Recommendation Report for Planning Permission for Works or Extension to a Dwelling

REF NO: BR/62/22/HH

LOCATION: 91B Gravits Lane
Bognor Regis
PO21 5LN

PROPOSAL: Erection of single storey rear extension and loft conversion to habitable space.

PROPOSED PLANS AND ELEVATIONS

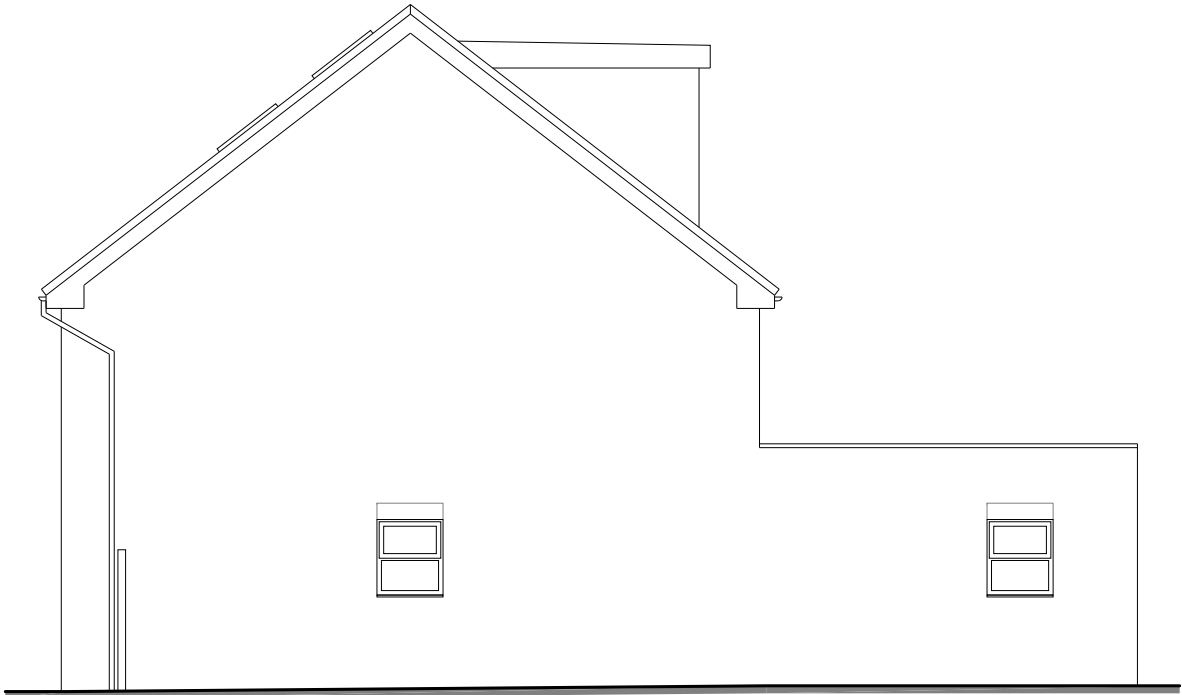
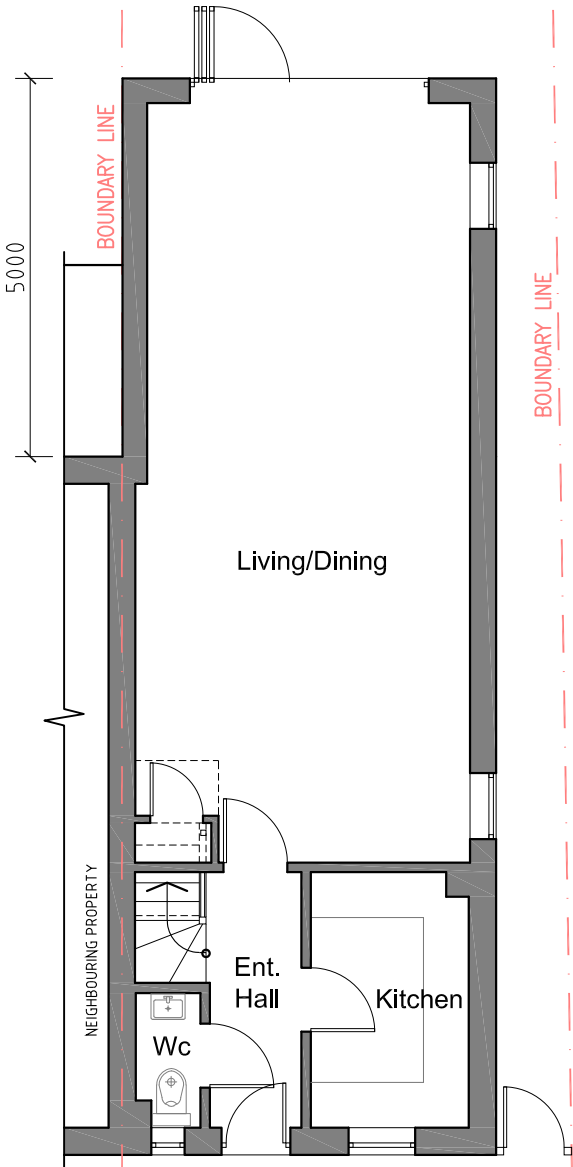
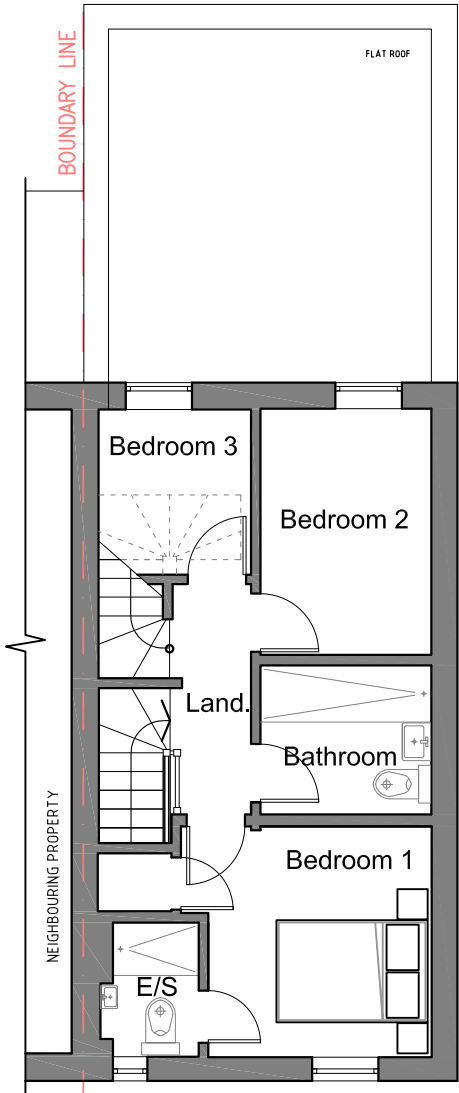
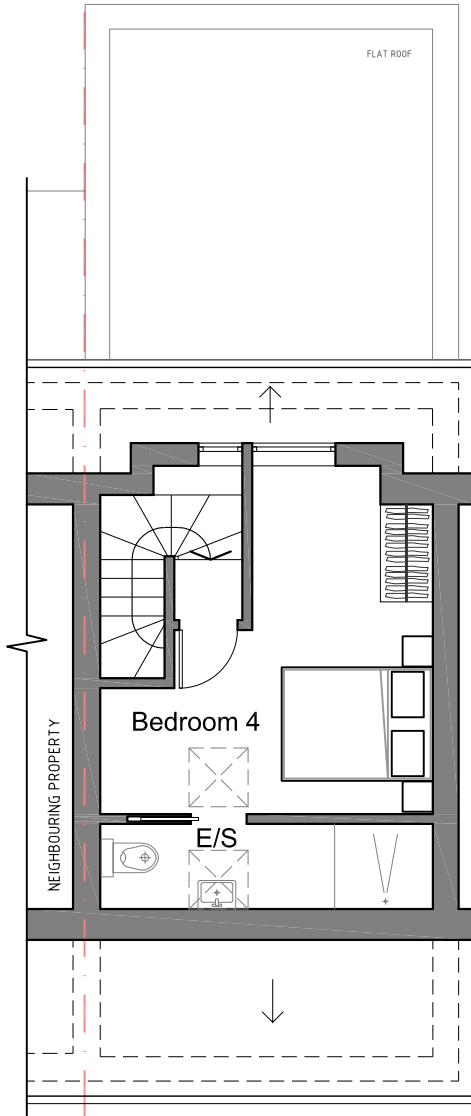
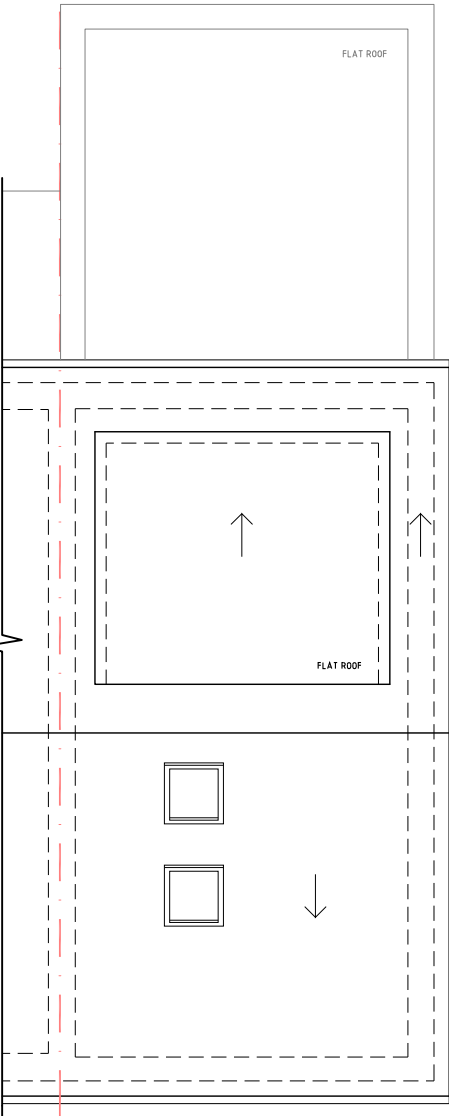
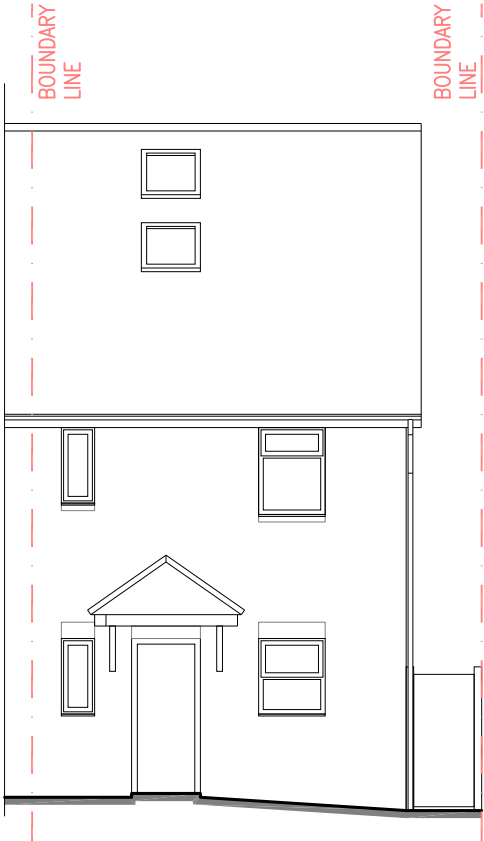
The proposal seeks an extension and dormer and being located to the rear of the property, the development is not visible from the street scene. There will be two rooflights to the front elevation although these are modest in size.

The dormer to the rear appears appropriate in scale and is set back from the boundaries.

The extension will have a flat roof and does add some bulk to the rear with the addition comprising some depth. It is well integrated through the use of matching materials which includes render.

The rear extension will have a depth of 5m and a height of 3.15m. This extends beyond the rear elevation of both neighbouring properties and will likely give rise to some overbearing.

The dormer will have a height of 2.3m, a width of 3.5m and a depth of 3.15m. This retains approximately 1m to the side boundaries and is located around 1m above the eaves. Due to its size, it will not result in adverse overbearing or overshadowing.

There will be a 2 windows serving bedroom and bathroom. This will provide additional views over the garden of neighbouring properties which are not currently achievable but similar to those from upper floors. This will although not give rise to adverse overlooking with no views direct into windows. Dormers can also be constructed under permitted development in some cases.

PROPOSED SITE PLAN
Sc. 1:200

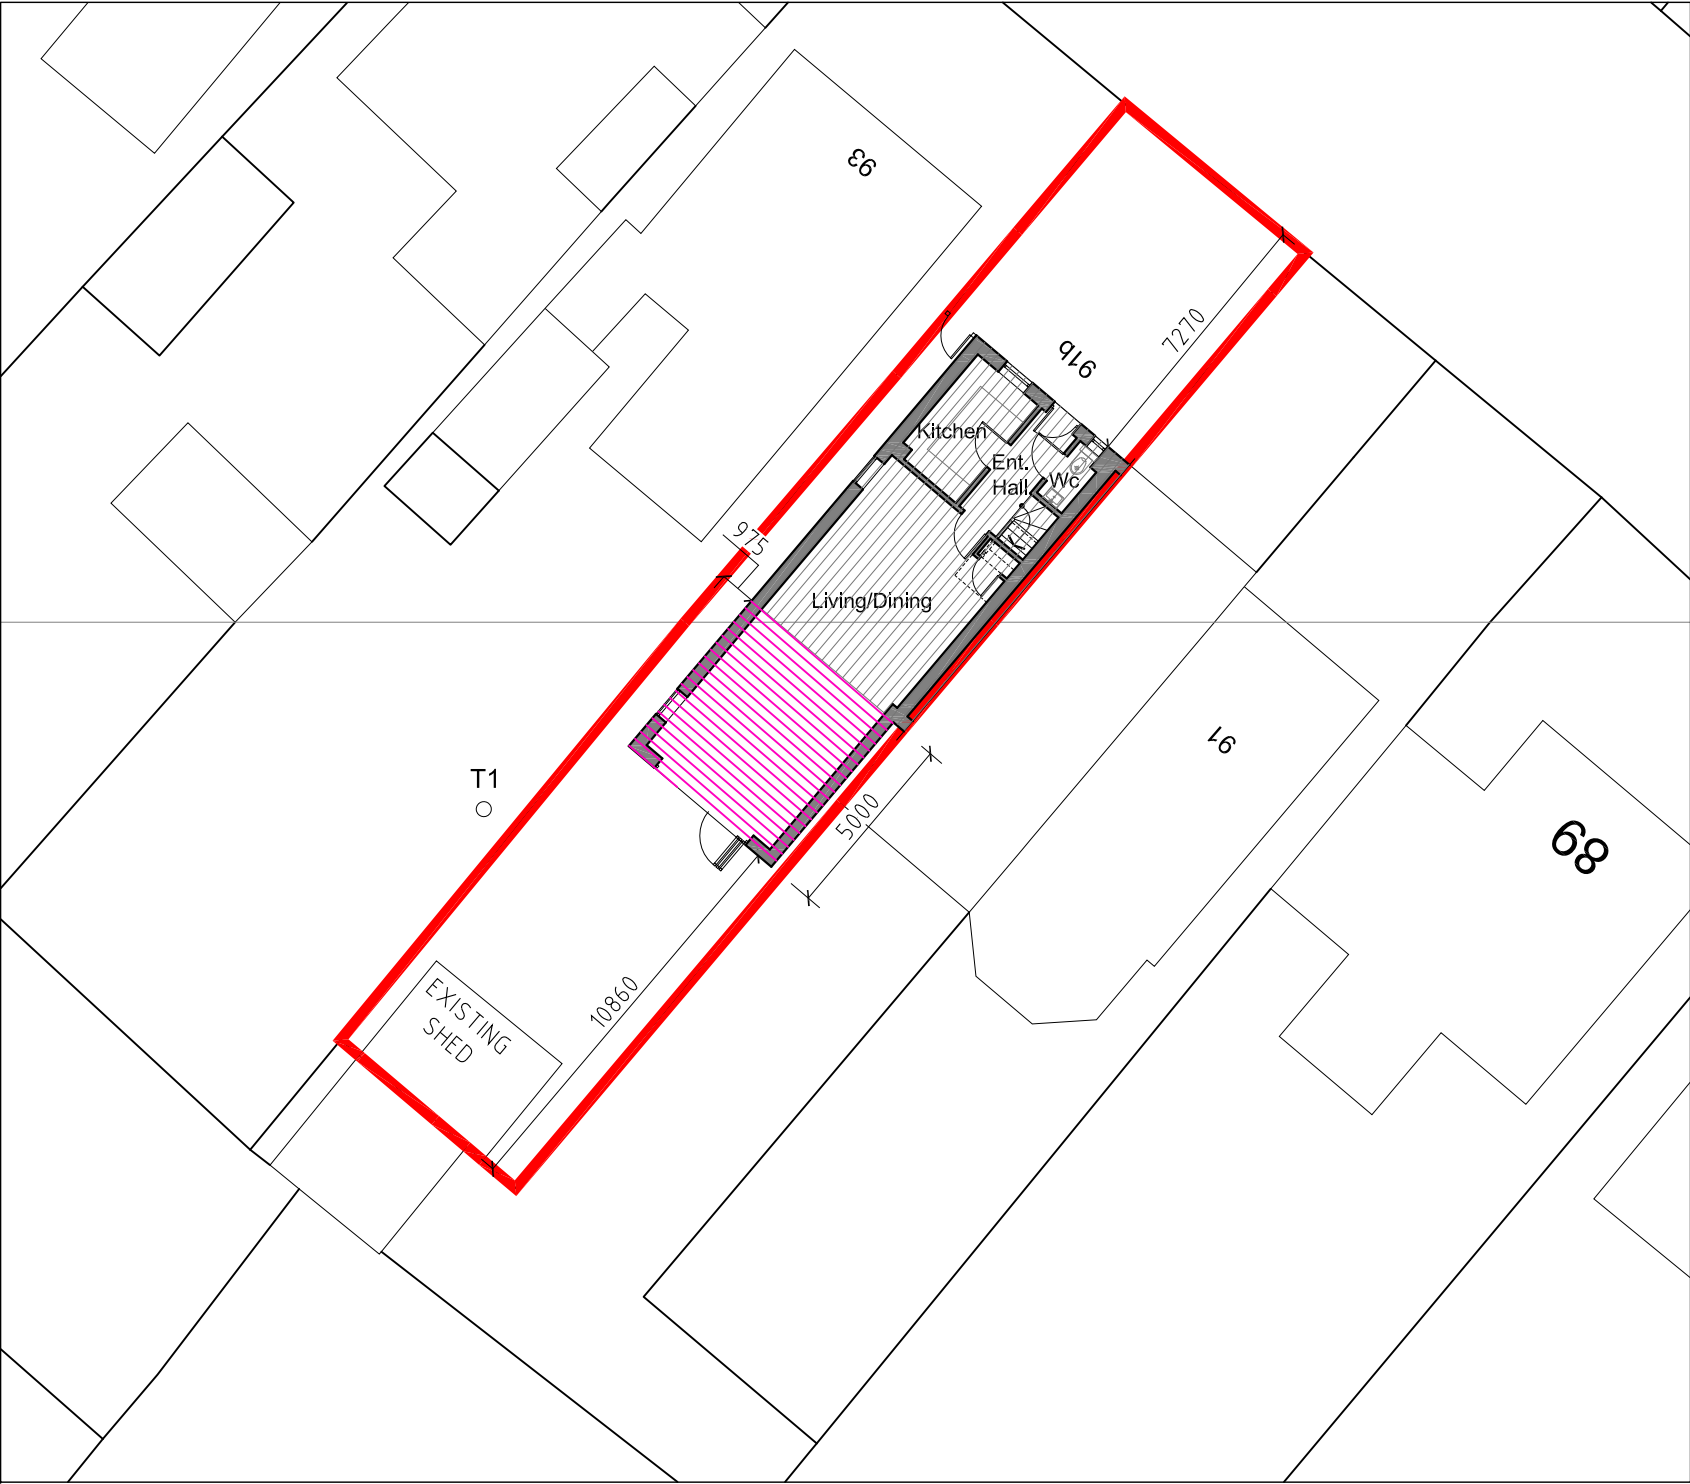
To the west, No.93 is set further back than the host property and has a conservatory to the rear. There is also a single storey addition along the western boundary that extends to roughly the same depth of the extension. The extension does extend some distance beyond the conservatory and will intersect a 45 degree angle. It will however not result in significant harm with some separation retained and will not intersect a 60 degree angle.

To the east at No. 91a, the property also has a rear conservatory. The proposed will extend around 2.5m beyond this. The proposal however does not intersect a 45 degree angle from the centre of this.
